Mr G E and Mrs A P Mathias
16 Tamarisk Way
East Preston
BN16 2TF

22nd July 2015

Objection to **EP/78/15/HH 14 Tamarisk Way**
Front Extension To Form Attached Double Garage

PLANNING	
 Only Extensions 0800 368 9810 info@onlyextensions.com	
PROJECT REF: Samlin, 14 Tamarisk Way, East Preston, West Sussex, BN16 2TF	
DRAWING TITLE: Roof Plan as Proposed	
Dwg No. 192-P32	Rev:

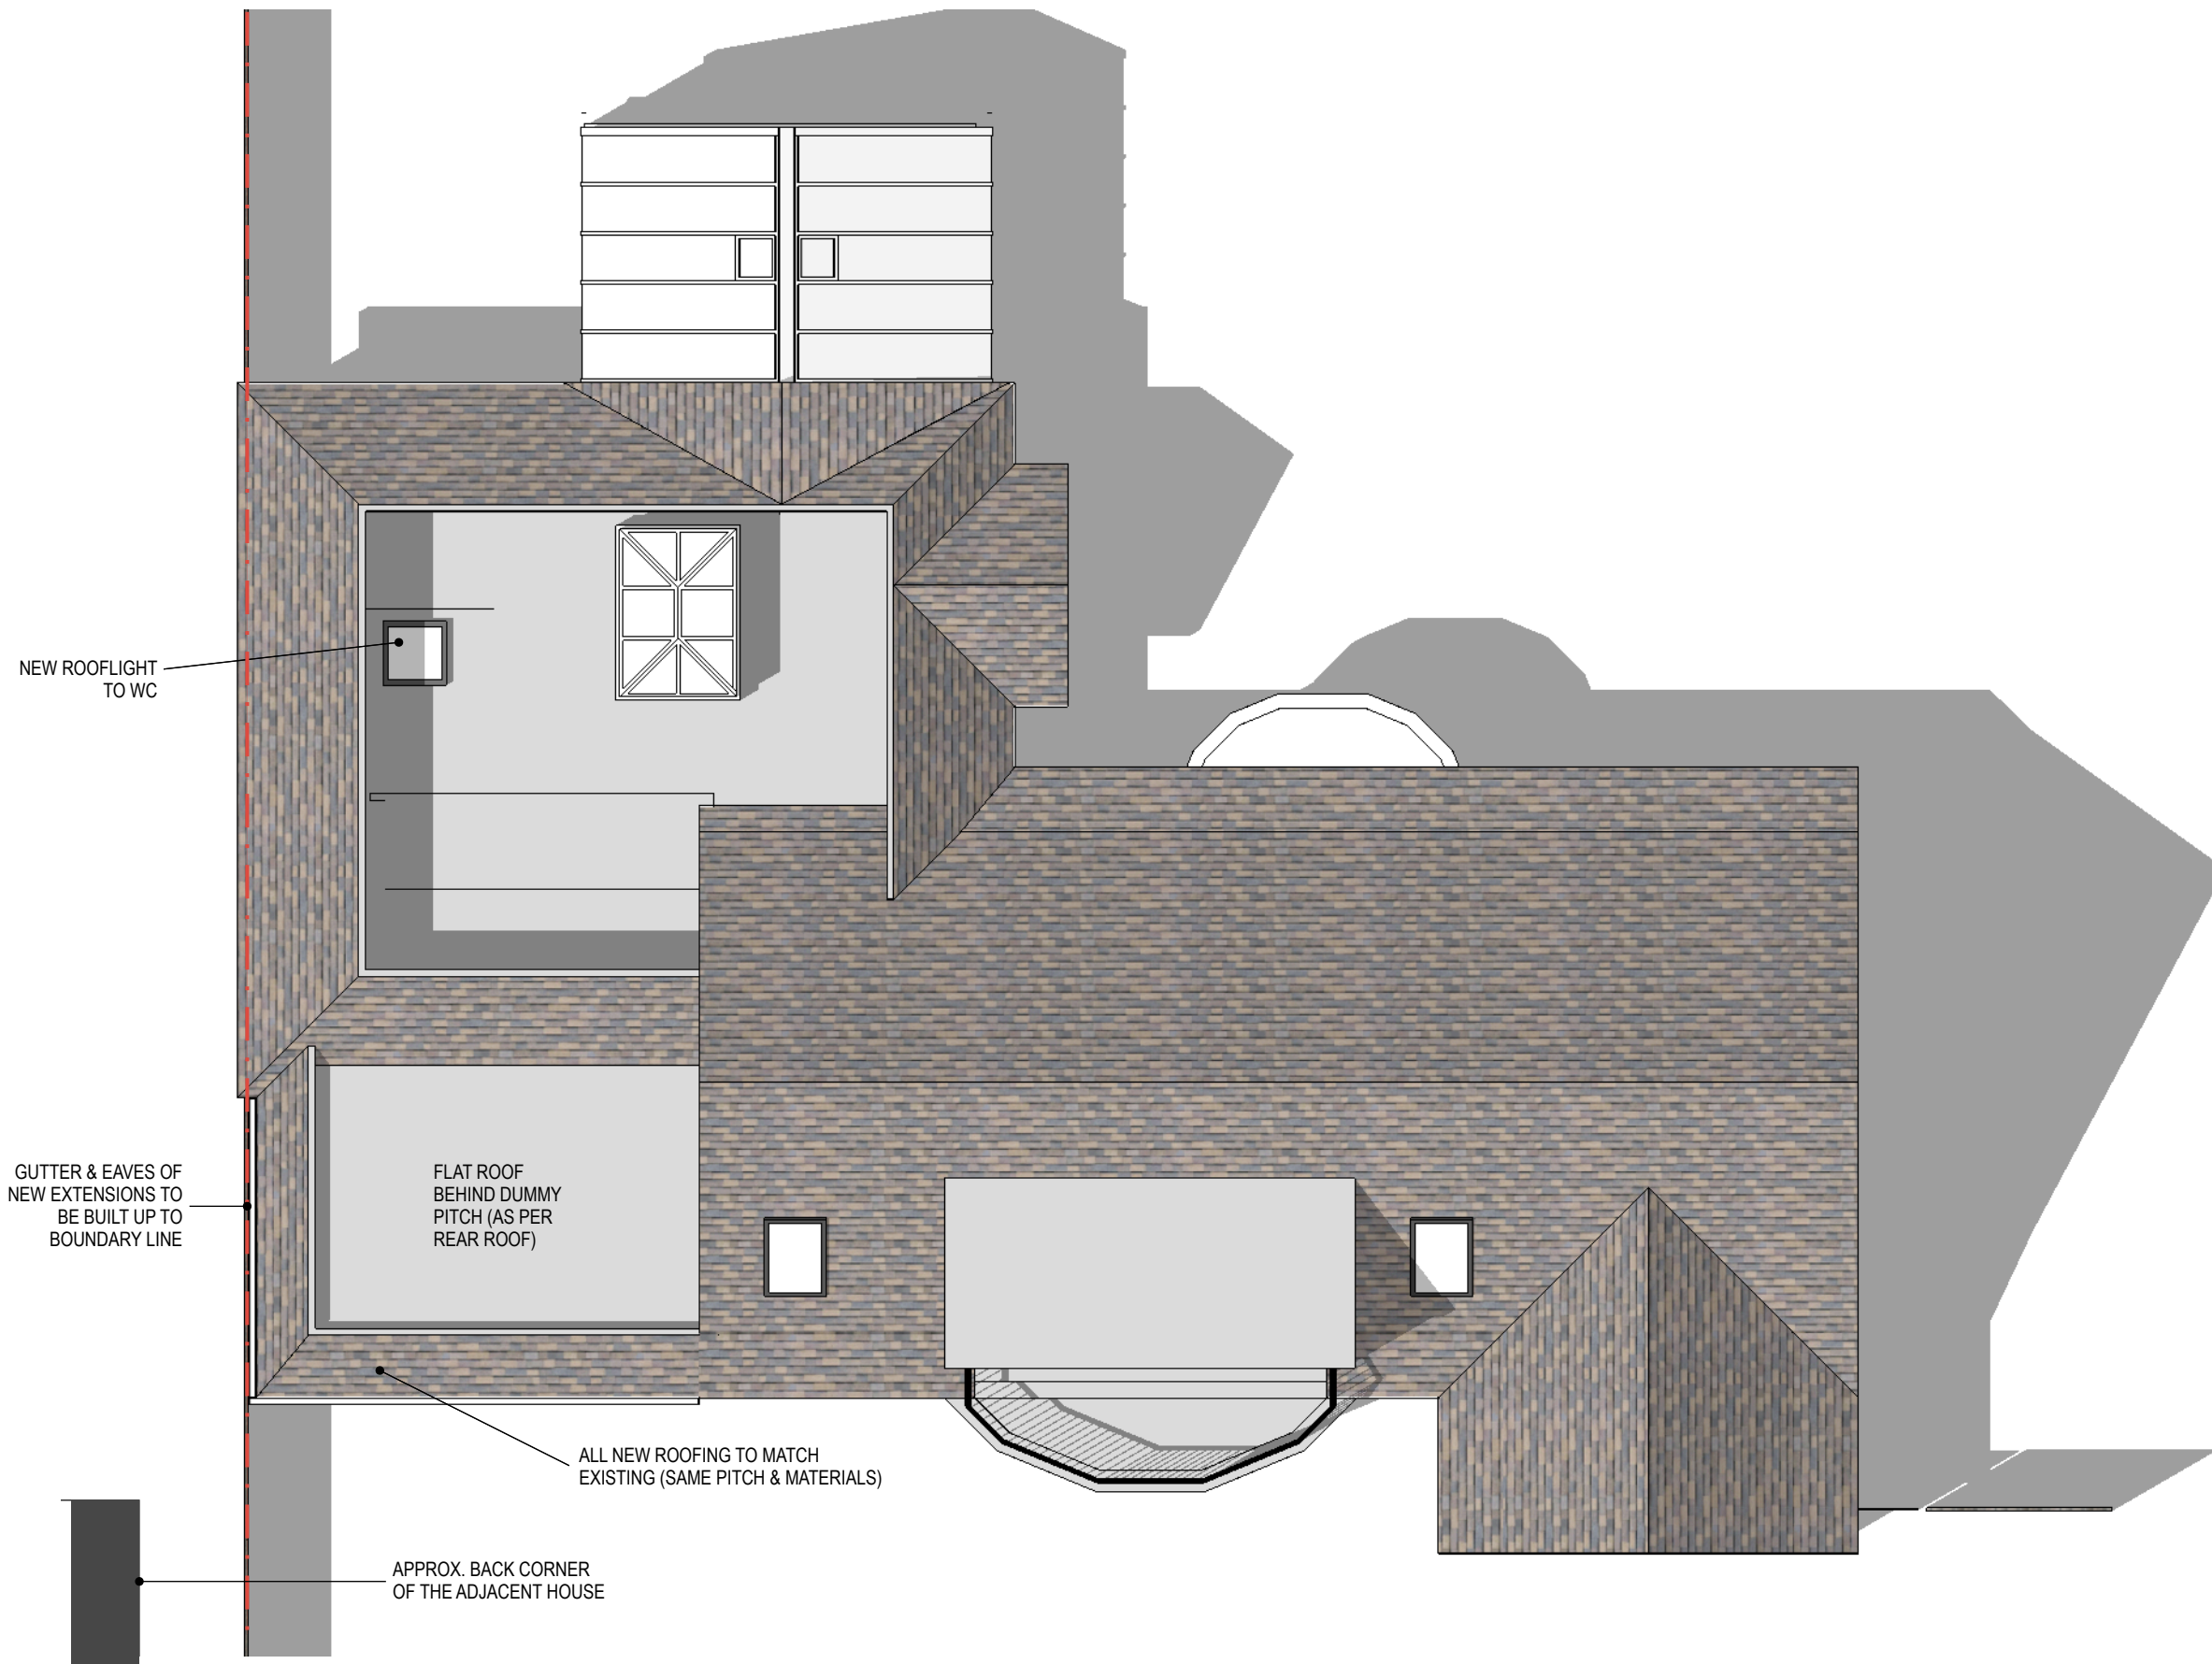
The current application proposes a further reduction in the roof height (unspecified) - but not in the height of the eaves, a reduction in length to 4.5 metres but no change in the width, "it would still be situated on the boundary without any separation distance".

Whilst the reduction in length and height in this proposal is a small improvement, because the extension is still to be built almost on our boundary it is not possible to mitigate or soften its impact on our living conditions. I believe that the only way to mitigate the harmful effect on our amenity is to re-site the extension approximately one metre away from the boundary and for the applicant to plant a continuation of the hedge along the side of the extension. This soft landscaping would soften the visual and overbearing effect of the extension and thereby reduce its harmful impact on our amenity.

South & West Elevations plus
Sections AA & BB as Proposed

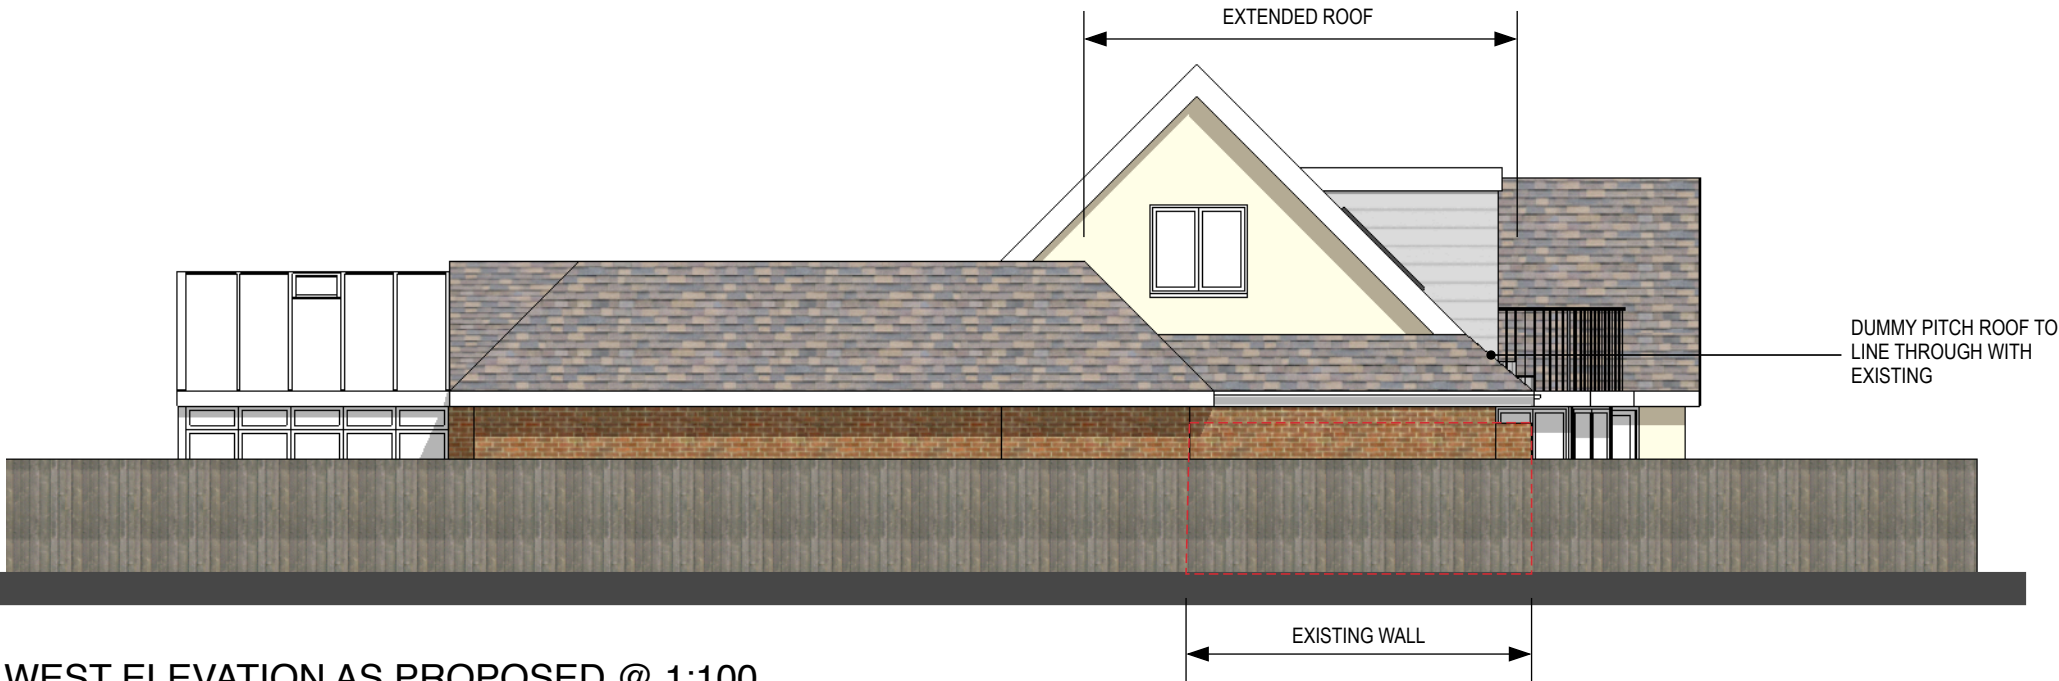
The extension is still to be built up to the Eastern boundary of our property adjacent to our patio and perpendicular to the rear elevation to our property which has a ground floor window, in close proximity of the boundary, that serves our kitchen. Although the extension has been reduced in length and a little more in height; when viewed from our kitchen the proposal would still have an overbearing impact because the reduction in length would not change how much of extension will be visible from the kitchen. Similarly when using the patio the reduced length of the extension would still be 4.5 metres adjacent to the most used part of the patio (i.e. not next to the rear wall of our house) and would still contribute to an adverse sense of enclosure, thereby causing harm to our amenity.
